Recommendation Report for Planning Permission for Works or Extension to a Dwelling

REF NO: R/205/21/HH

LOCATION: 8 Frobisher Way
Rustington
BN16 2BA

PROPOSAL: Single storey porch extension and alterations to the external fenestration.

DRAWING TITLE:
PLANS & ELEVATIONS Proposed

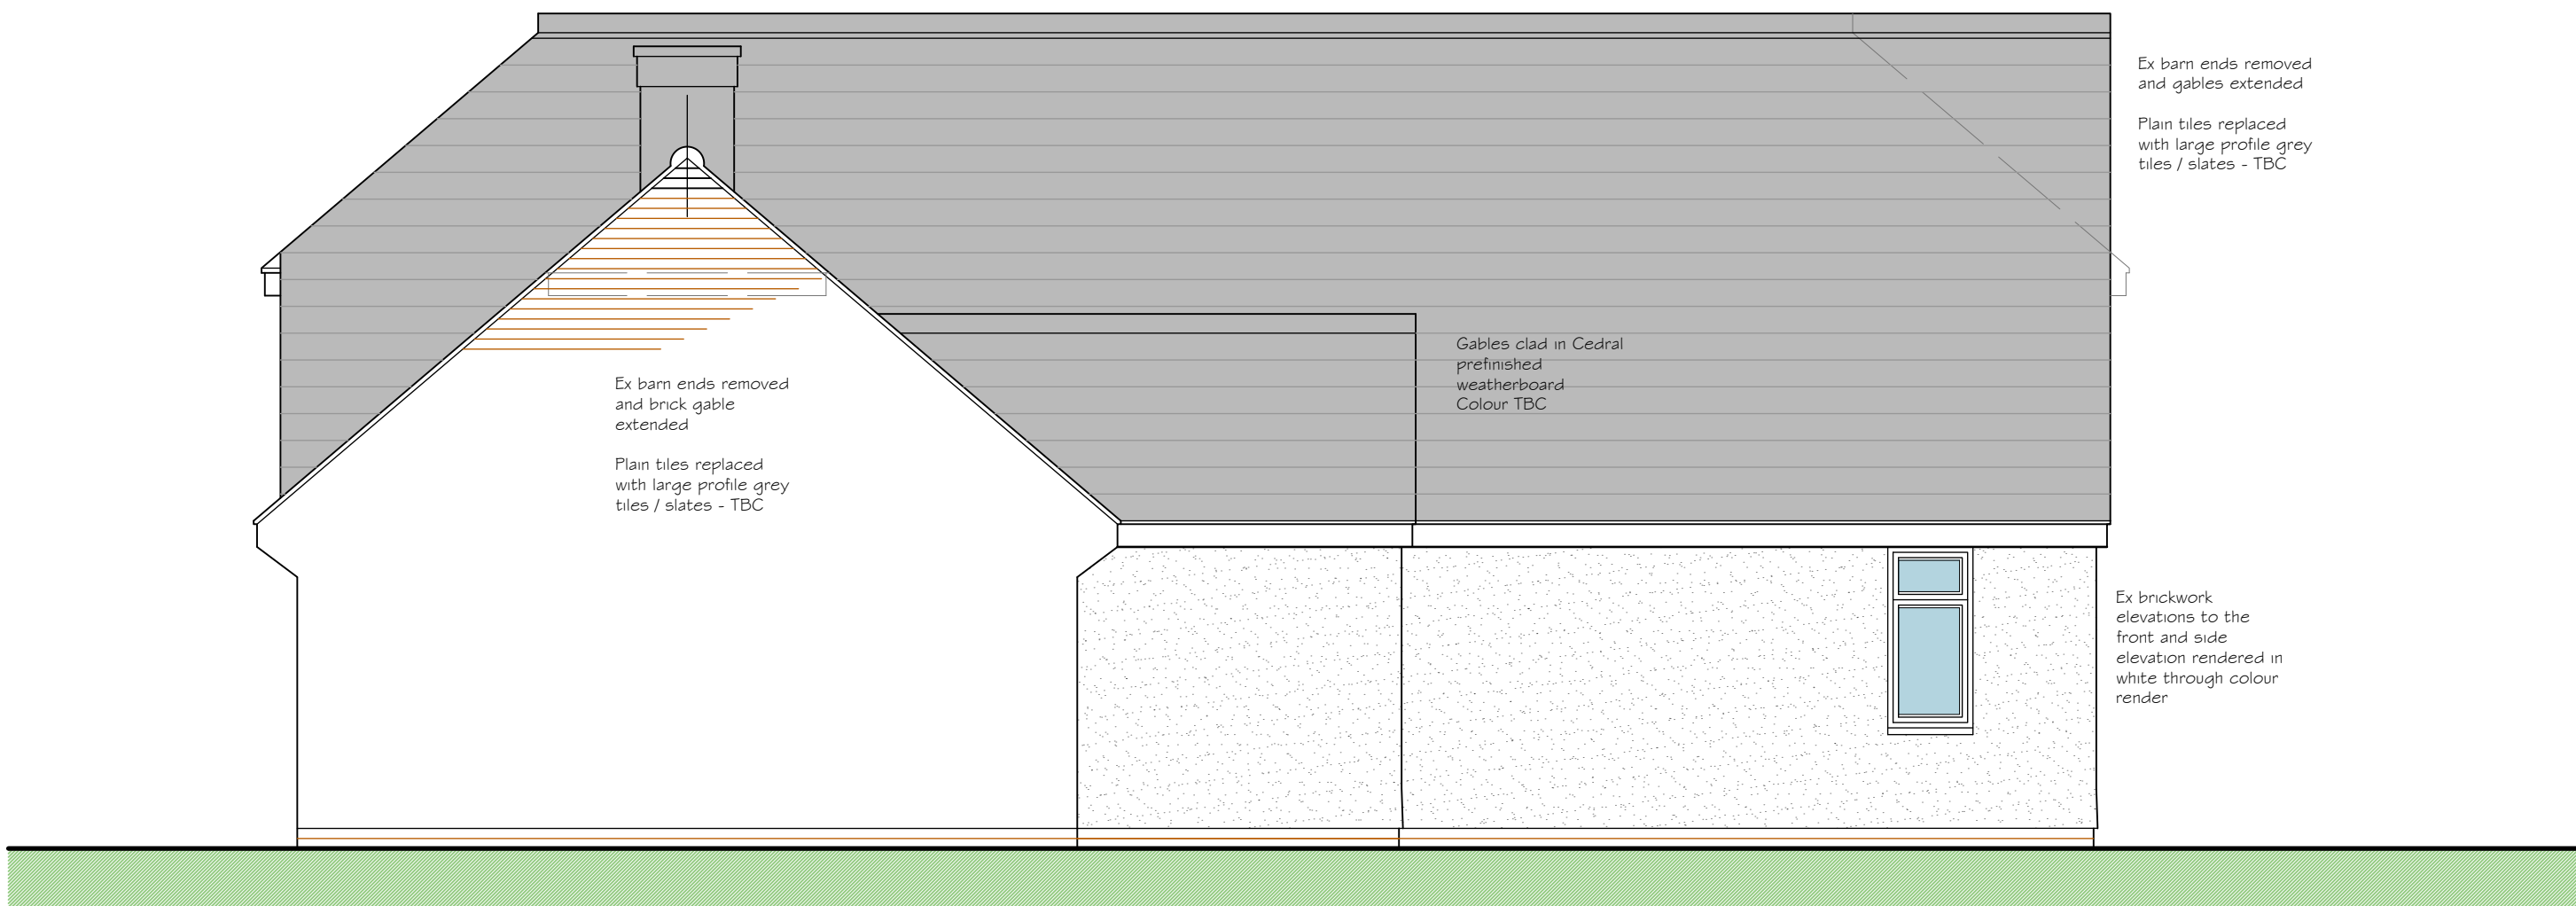
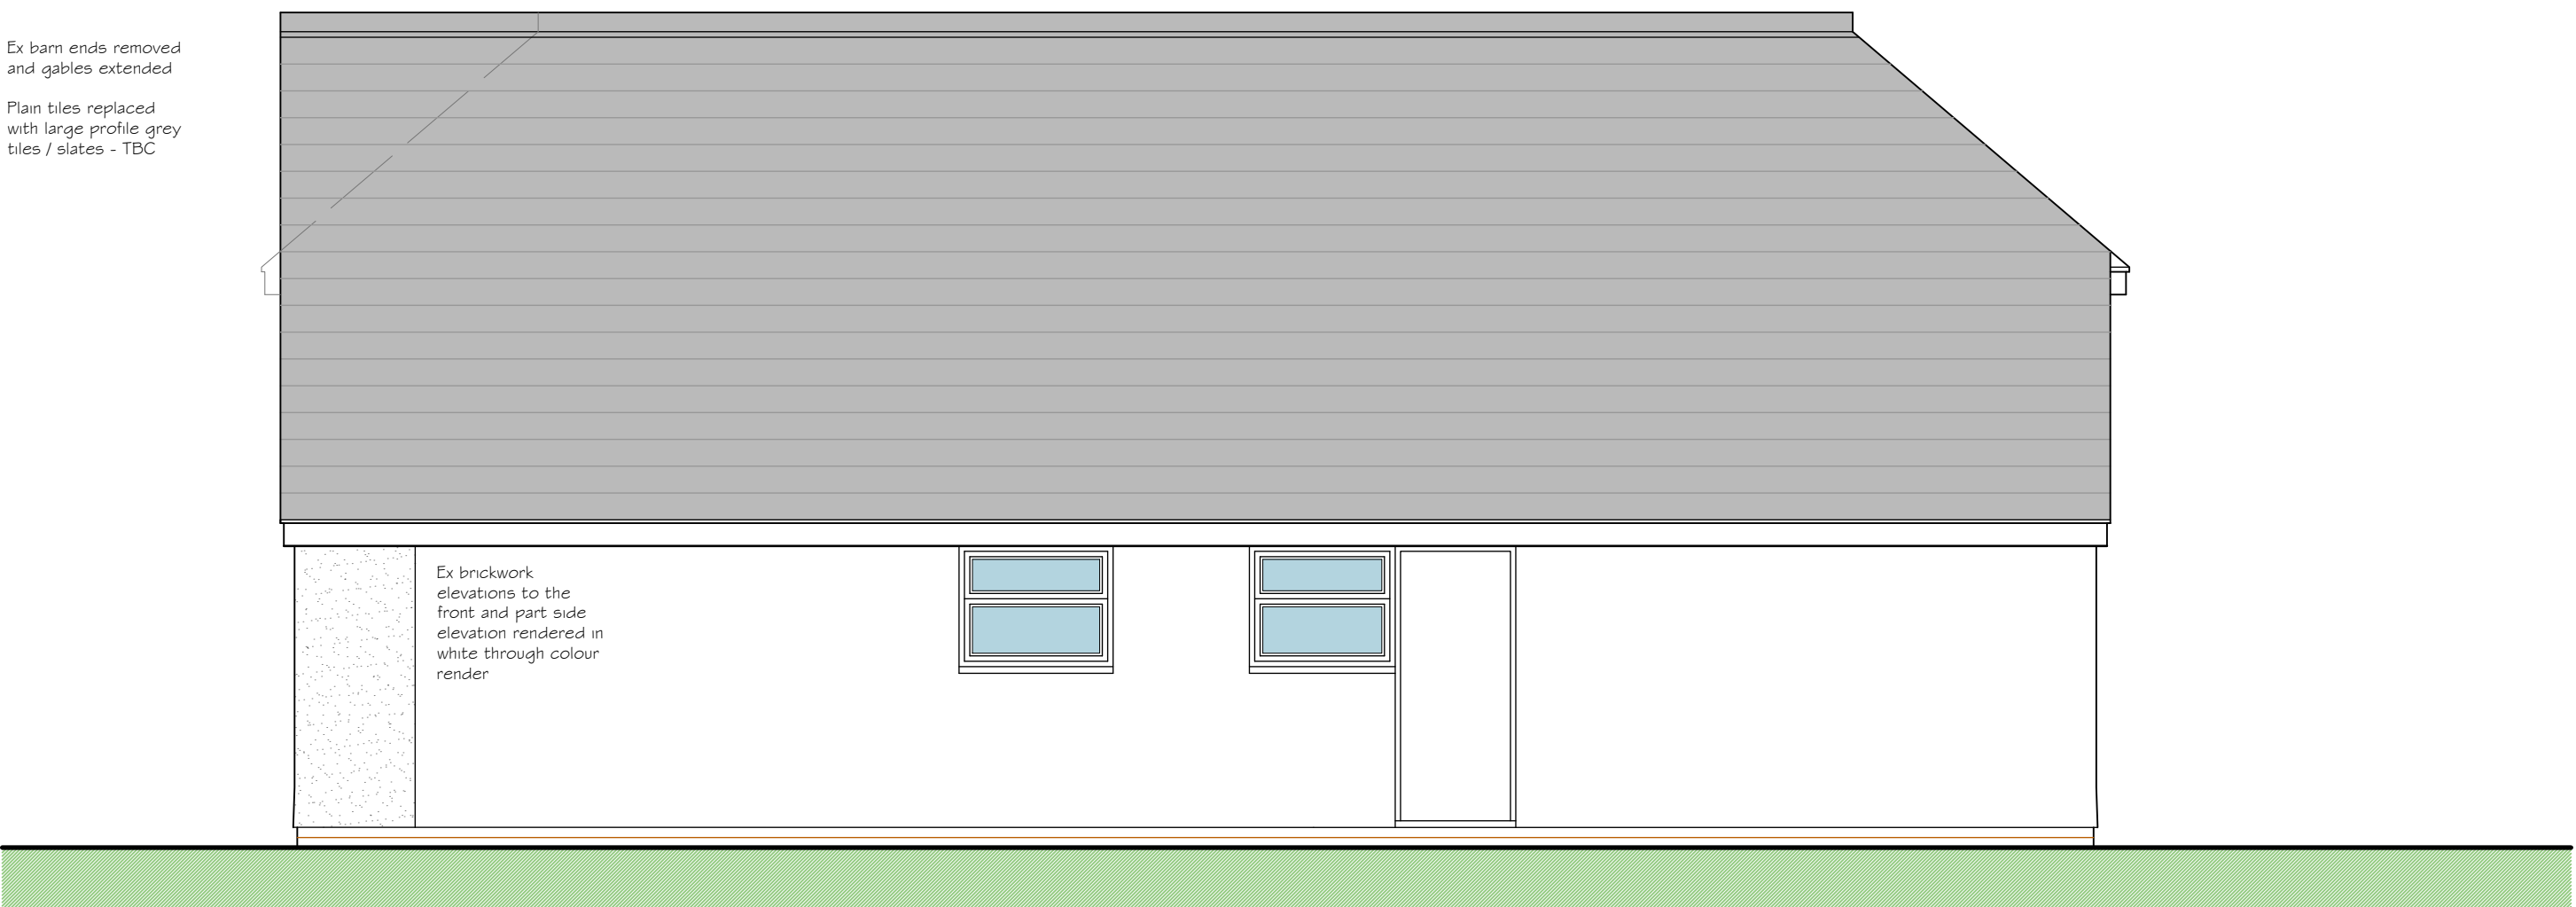
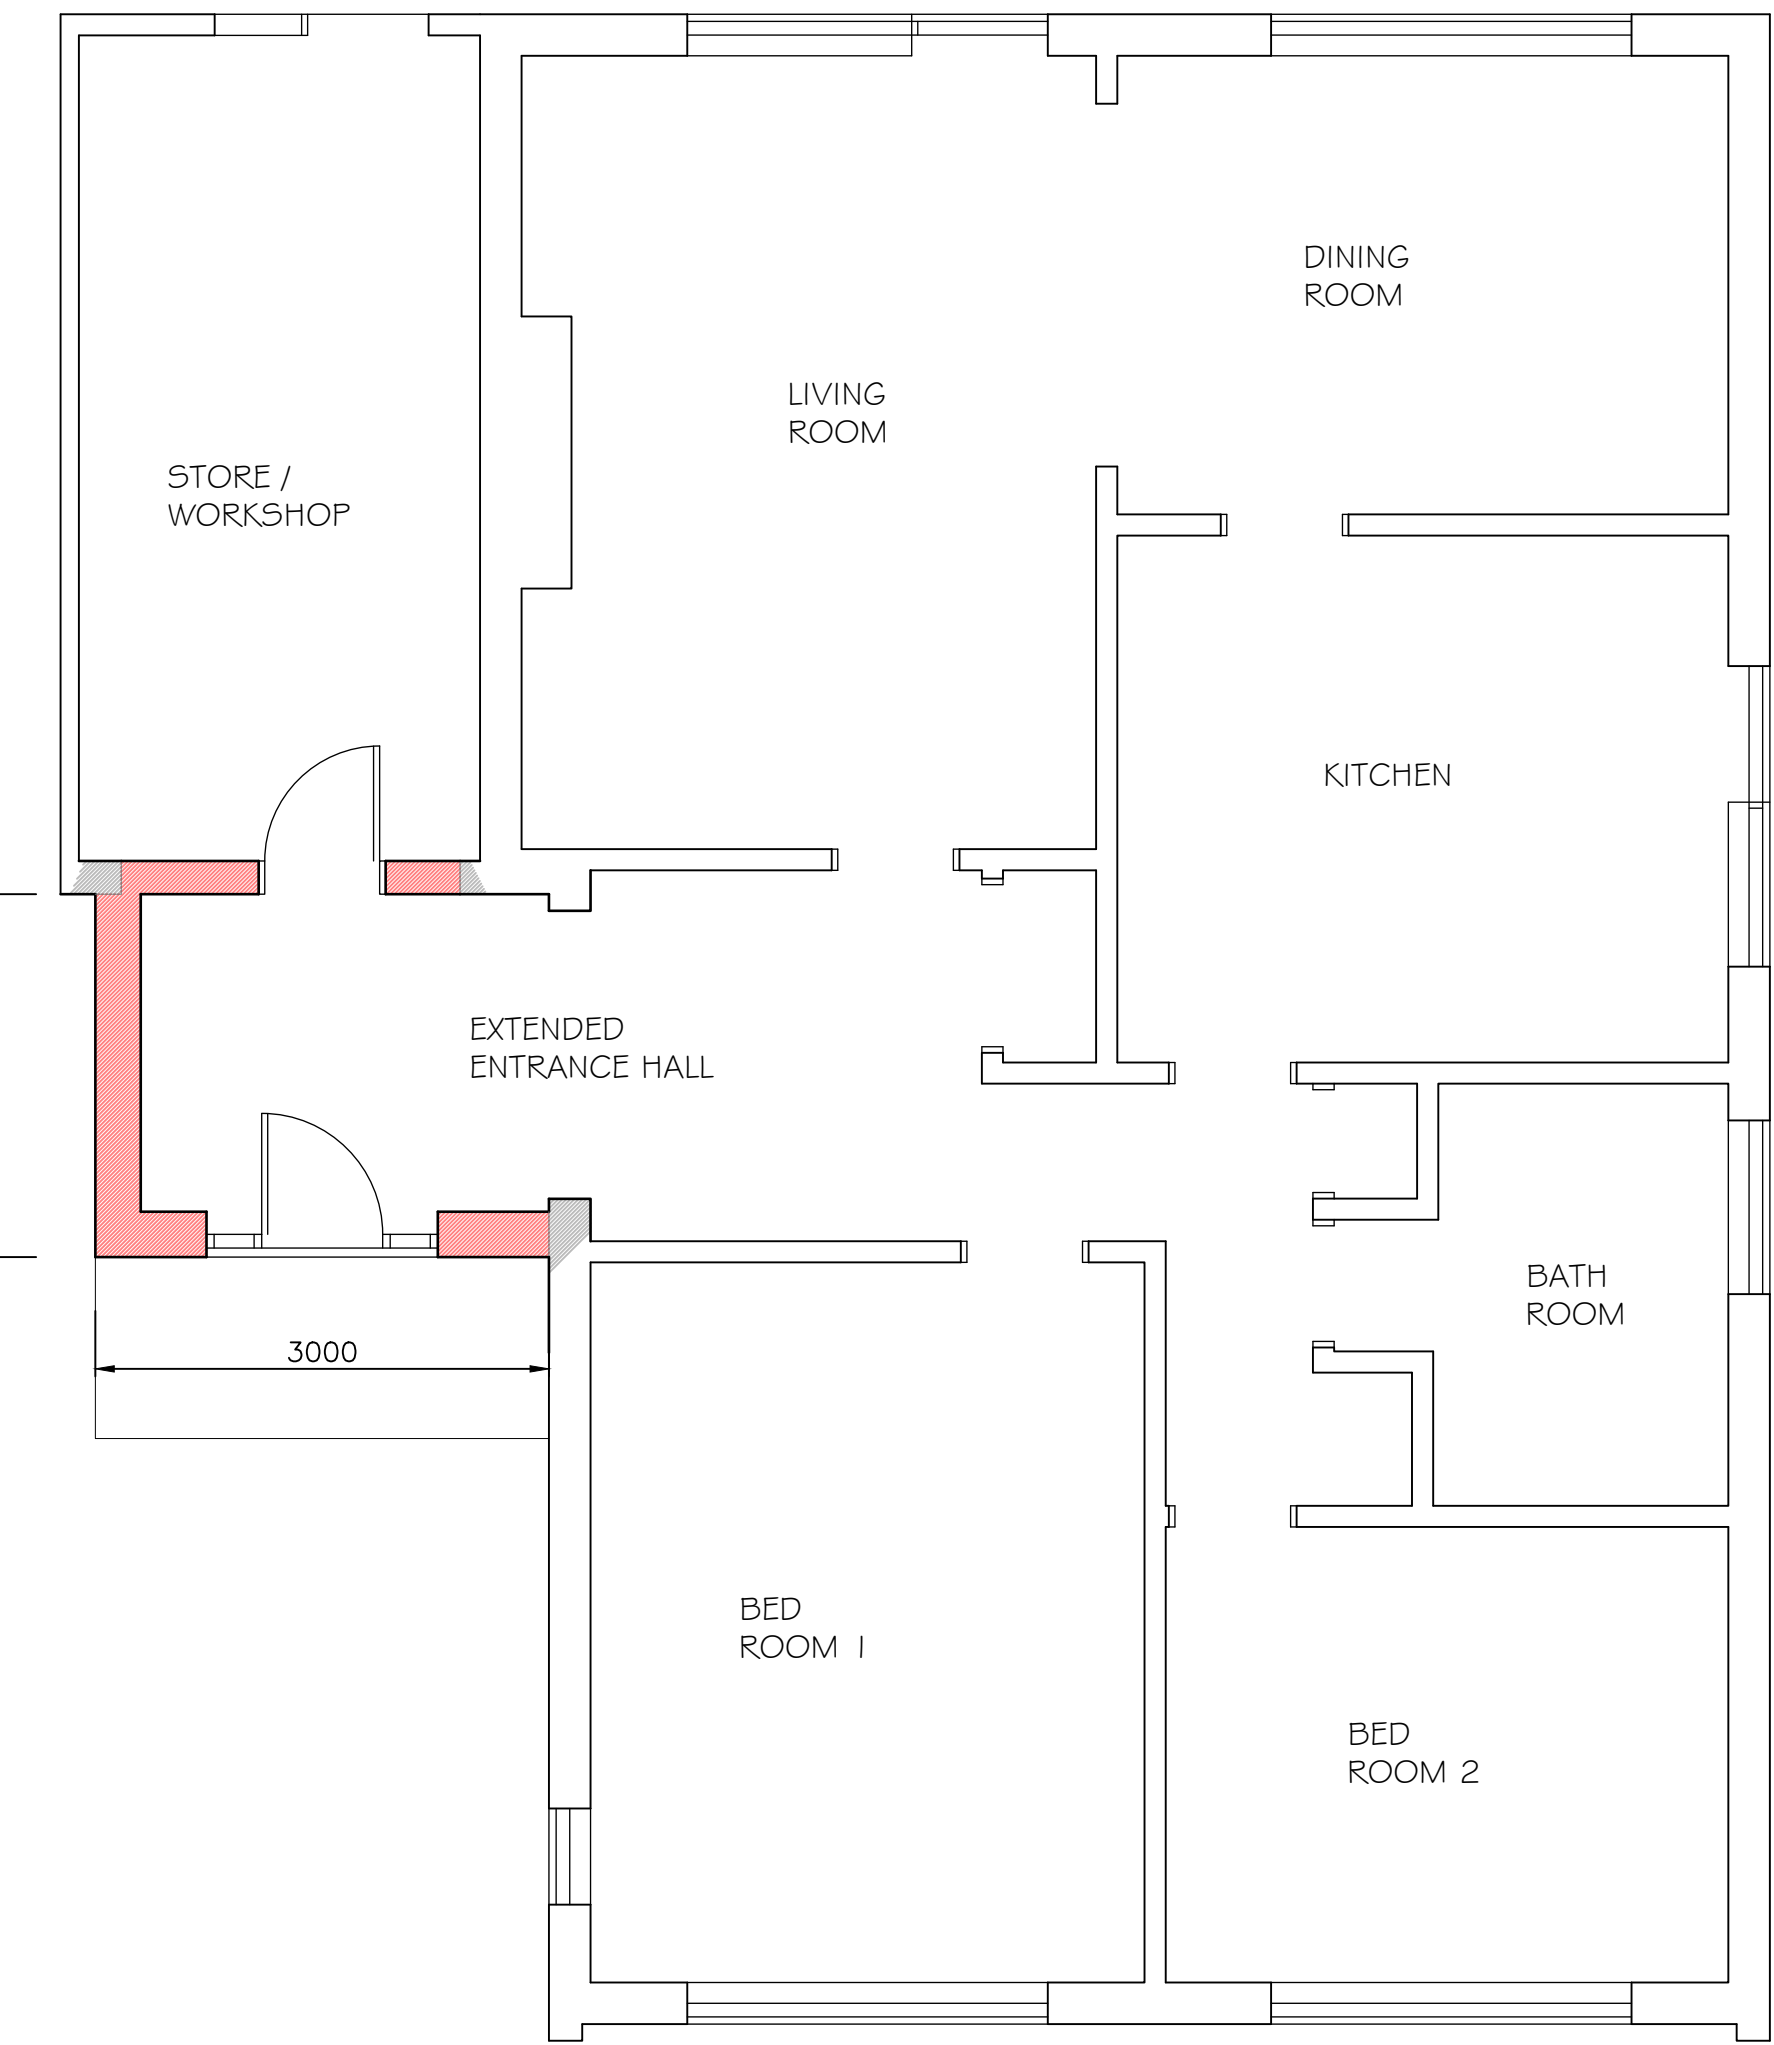
The proposed porch will be sited to the front side (south) elevation in front of the converted garage which will form a store/workshop. Due to the siting at front it will be highly visible from the street scene however being at single storey it is visually subservient to main dwelling and pitched roof design visually integrates with main dwelling roof so complies with policies D DM1 of the Arun Local Plan. The proposal being set back by around 19.1m from front (east) boundary further reduces impact on street scene so it is less significant and does not harm surrounding character of area.

The proposed porch extension will have a width of approximately 3.00m and a depth of approximately 2.40m. The height to pitched roof will be approximately 4.00m. There is 1m remaining to south boundary. There will be one new door to front (east).

The existing brickwork elevations to east elevation, south elevation and part north elevation will be rendered in a new white through colour render (the face brickwork will be retained elsewhere).

The gables will be clad in Cedral prefinished weatherboard colour TBC.

The proposed materials of through white colour render walls, grey concrete interlocking slates and White & Anthracite PVCu door seems to integrate with existing property and are not out of character with surrounding area so complies with policies D DM1 and D DM4 of the Arun Local Plan.

The proposal will have a width of approximately 3.00m and a depth of approximately 2.40m. The height to pitched roof will be approximately 4.00m. There is 1m remaining to south boundary and a gap of around 19.1m remaining to front (east) boundary. There will be one new door to front (east). Due to the siting to side (south) elevation there is increased risk to overshadowing or overbearing effects to neighbouring property number 10 Frobisher Way to south however due to being at single storey, existing boundary fence and gap of around 1m to boundary fence and 2m to neighbouring property there is no adverse harm caused.

Due to one new door to front (east) there is no harm to overlooking to south due to existing boundary fence and to east due to large gap of around 19.1m remaining to front (east) boundary.
